Broadland District Council Response to Examining Authority's Written Questions (ExQ1)

Deadline 1 (6th July 2021)

## Annex B. Proposed drainage layout plans

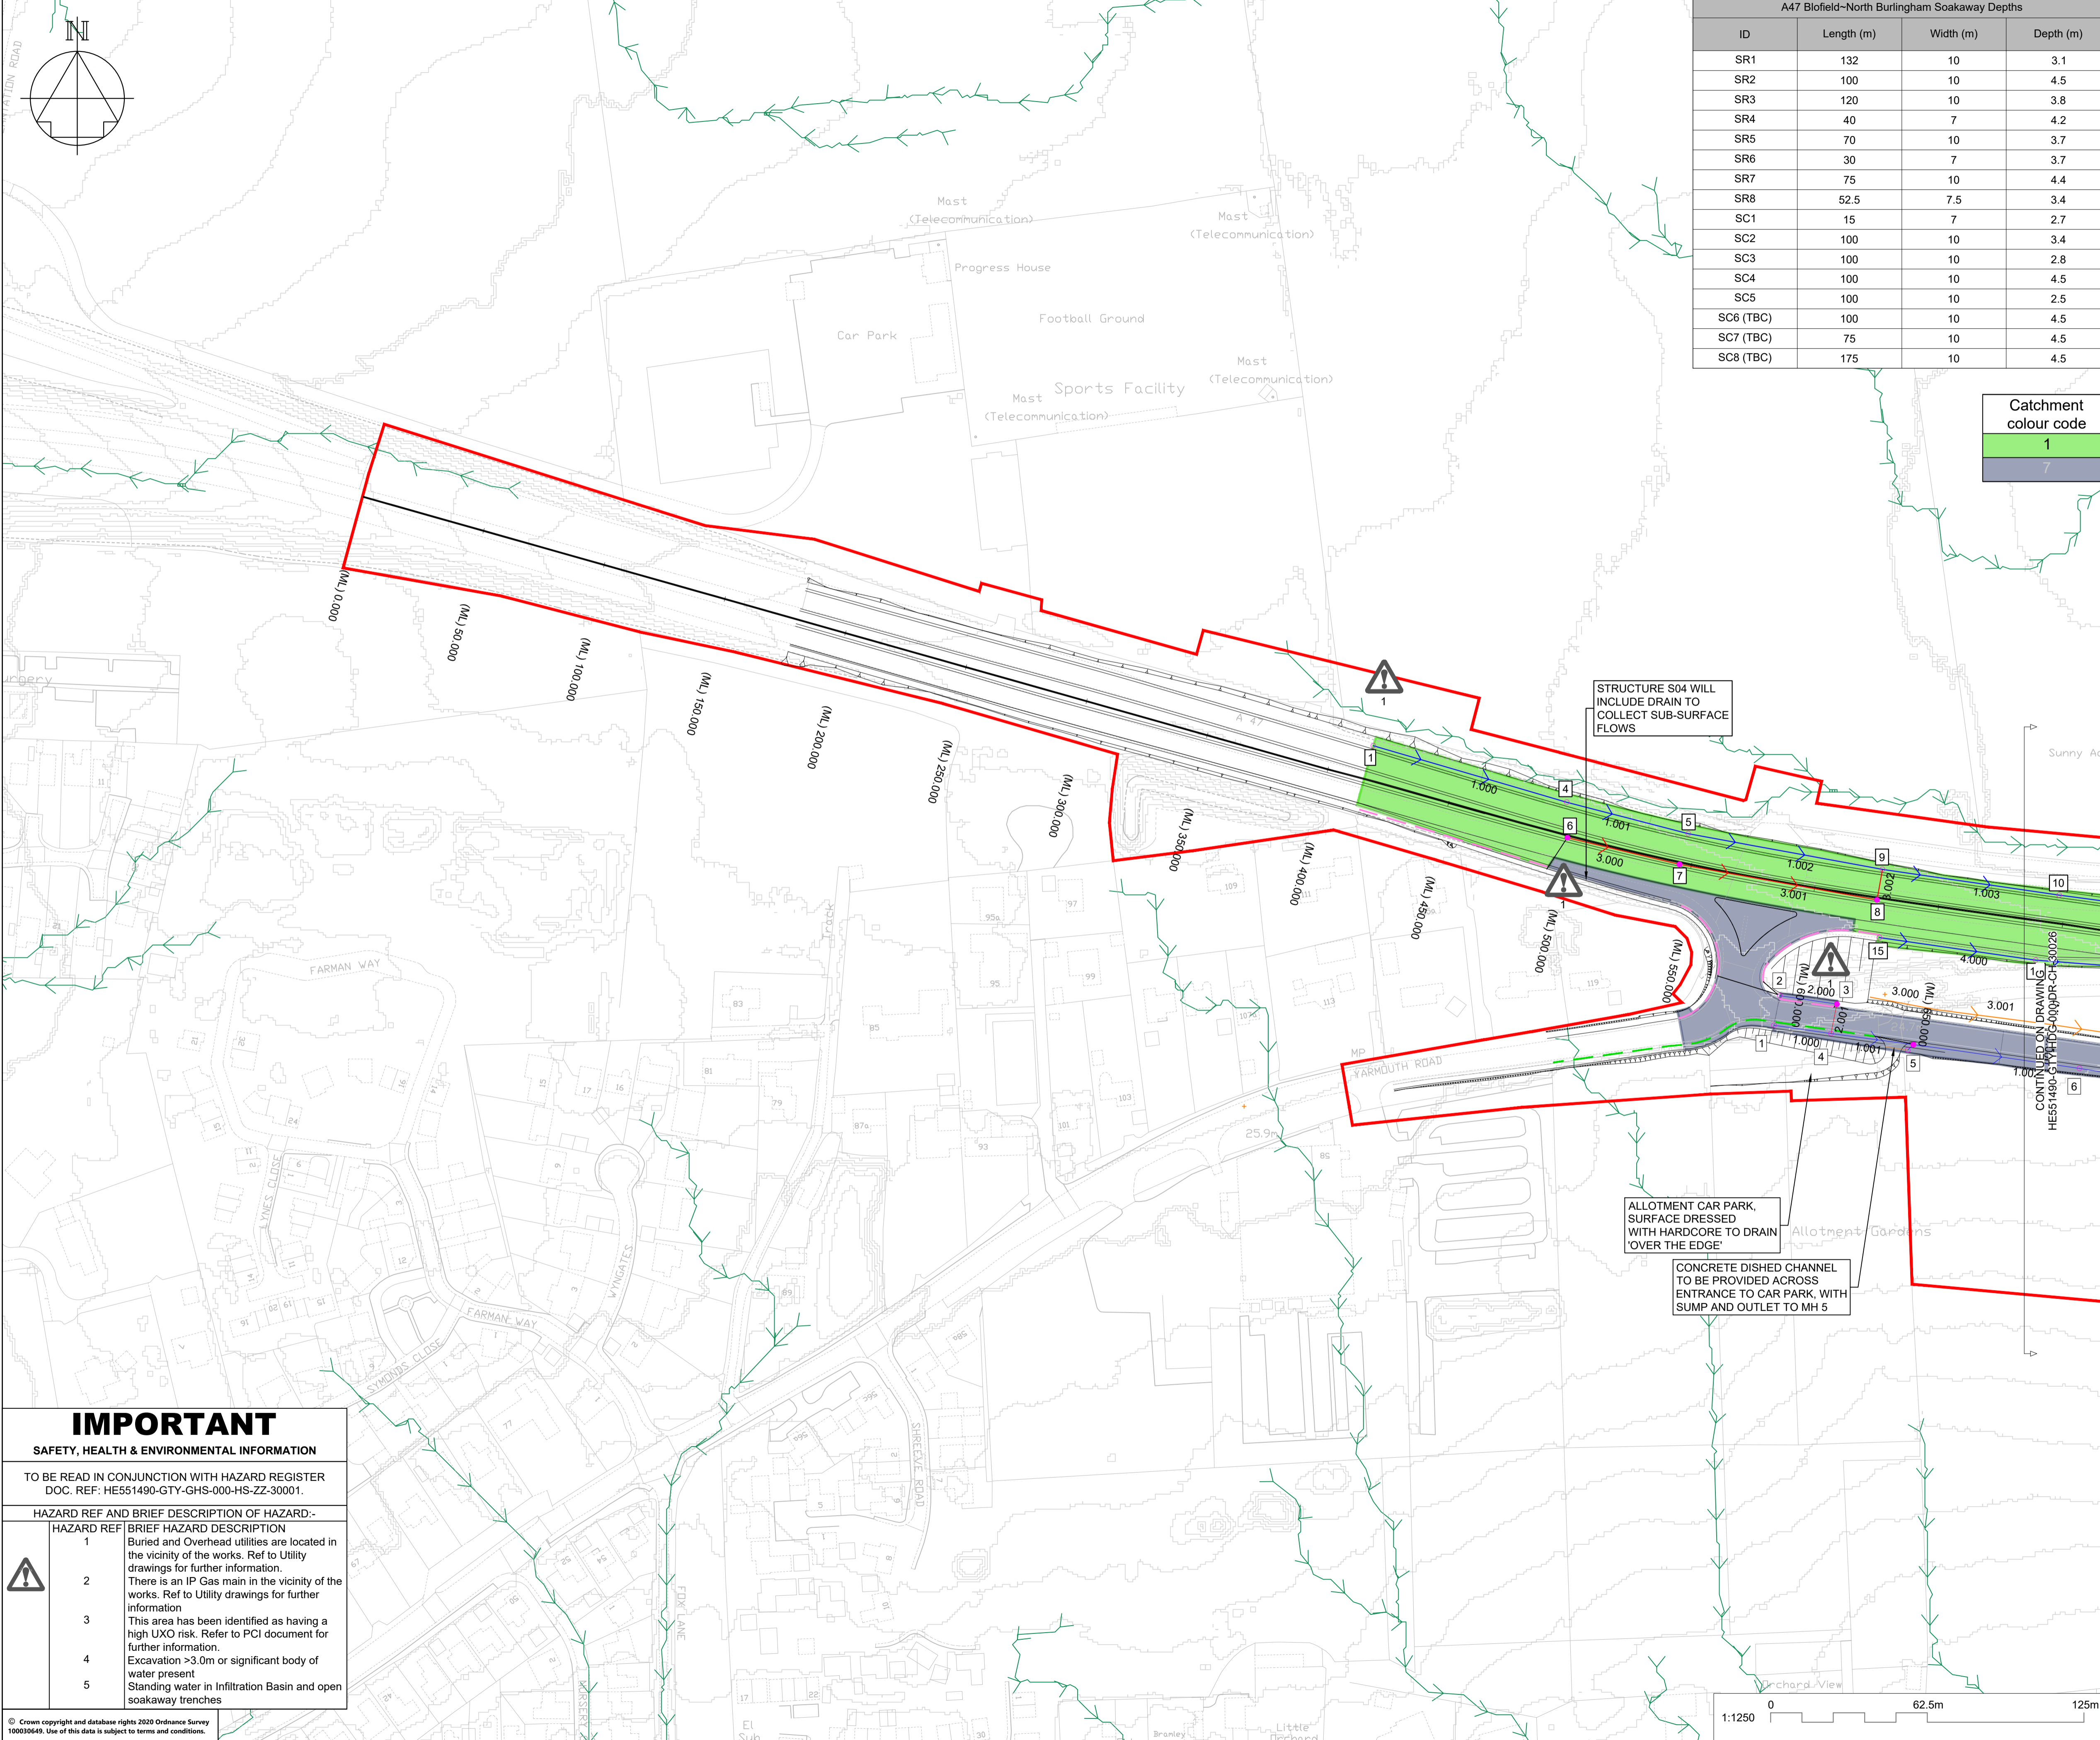
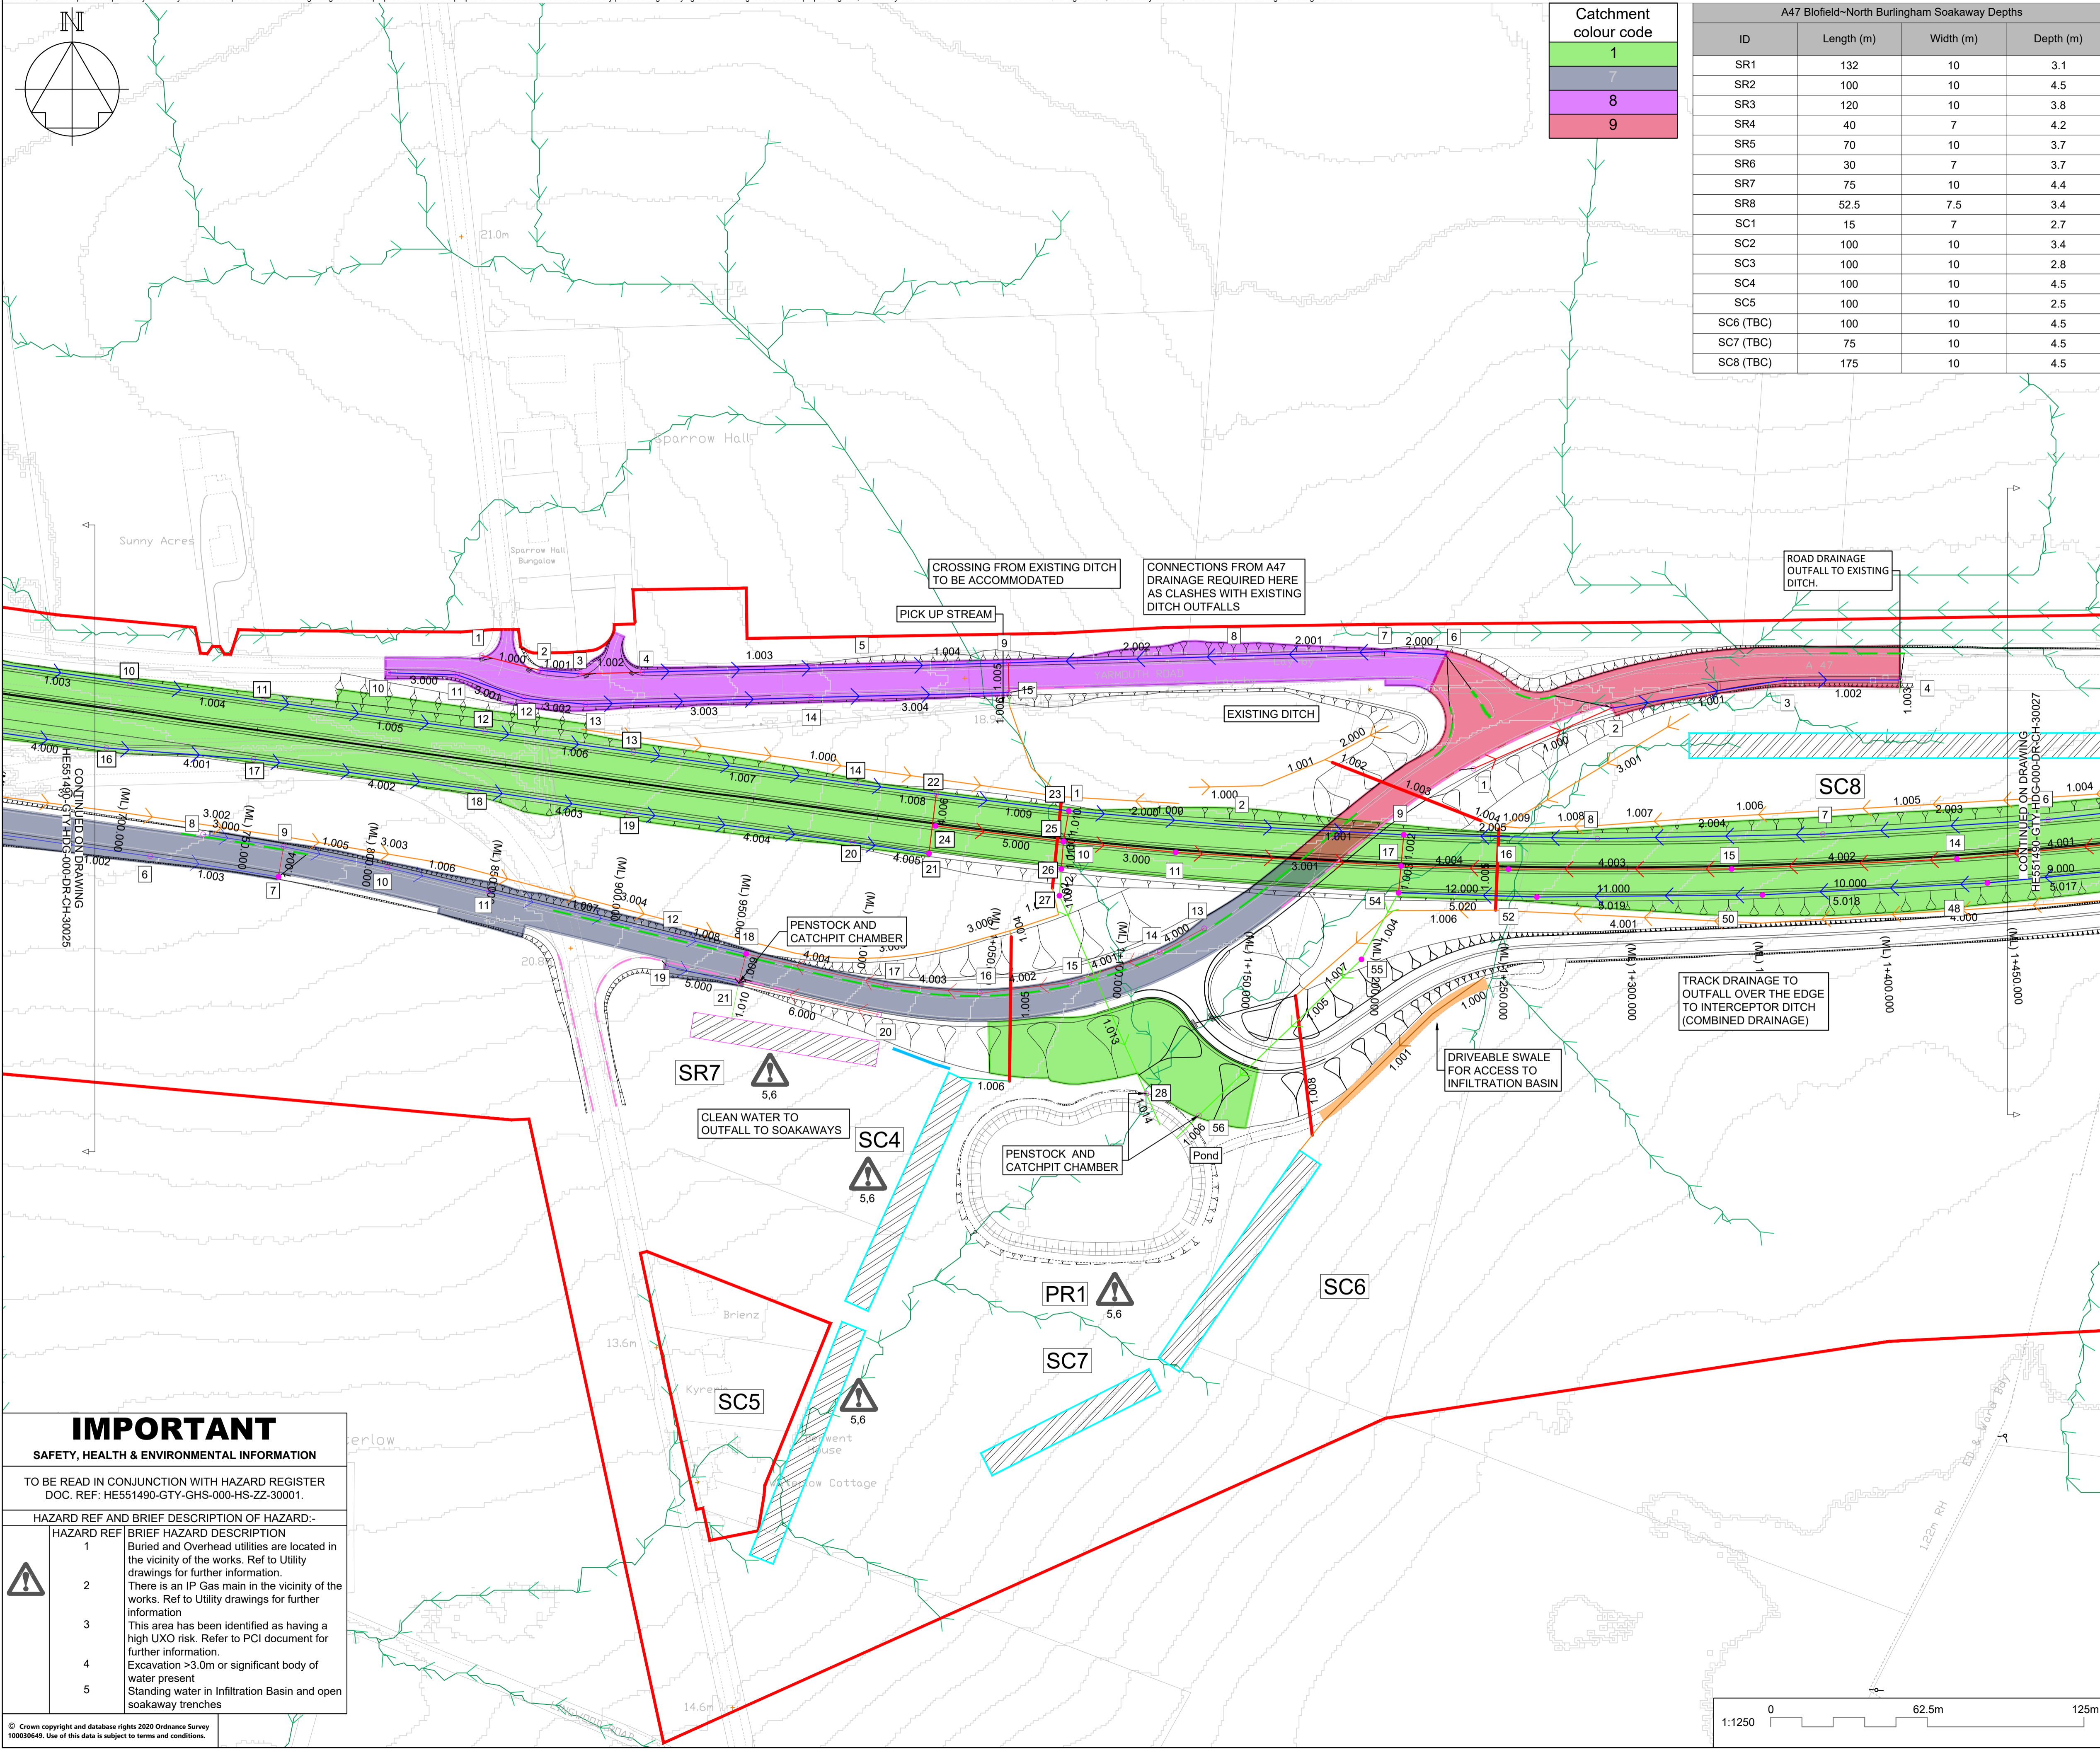
1.15.10	RR [RR-053] raises a concern around potential for increased flood risk to Waterlow Cottage as a result of the Proposed Development. Please provide a response to this concern.	We would endorse the comments from the resident and suggest that the applicant makes personal contact with Mr Trawford to explain the significant drainage proposals here including details of its design performance to hopefully demonstrate that it will operate satisfactorily without a positive outfall and not increase the water table and cause issues at the properties at Waterlow. The soakaway scheme does seem to be close to the eastern boundary of the houses.
